Application number: 2024/0664

Description: Change of use from bookmakers (Sui generis) to tanning salon (Use Class E)

Location: 8 - 9 Market Place, Cudworth, Barnsley, S72 8LX

Drawing Title **PROPOSED ELEVATIONS**

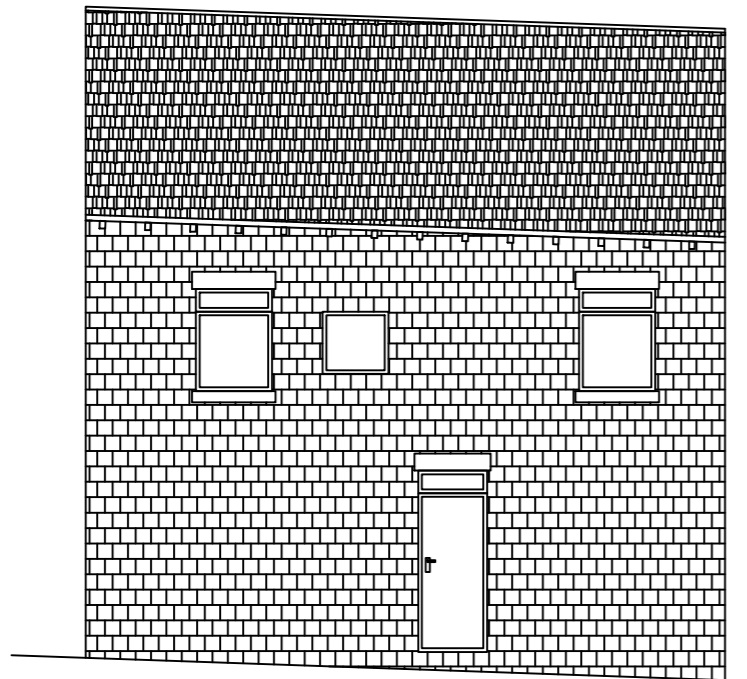
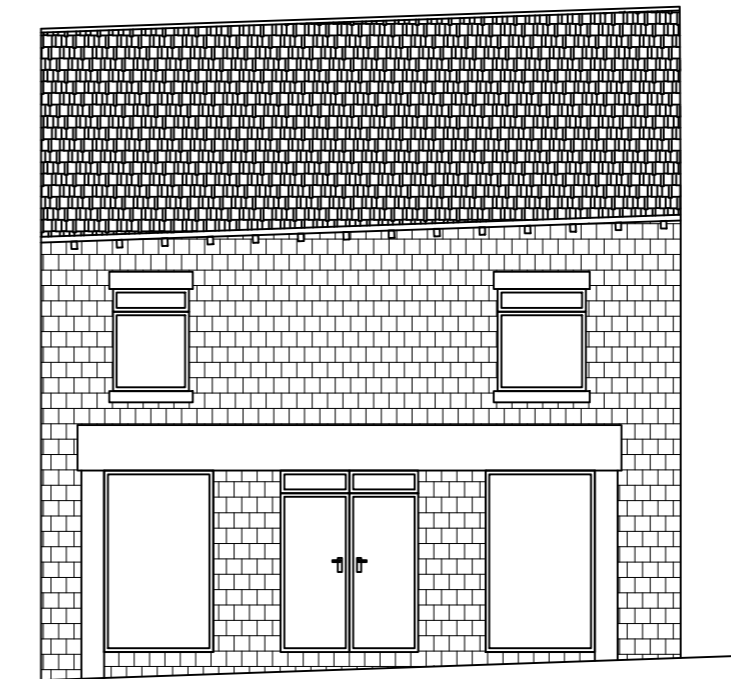
7.5. The applicant has stated that there would be changes to the front and rear elevations, the front elevation is to be renovated, whilst the applicant is also seeking to remove windows and replace the current wooden frames with UPVC frames in white. The applicant has stated that all materials used are to match the existing building. The removal of the windows to the rear would be a welcomed addition as currently the windows are sporadic, this would create a more uniformed look which would be more visually appealing. Therefore, the changes to the elevations would not cause a detrimental effect on visual amenity, rather improve it.
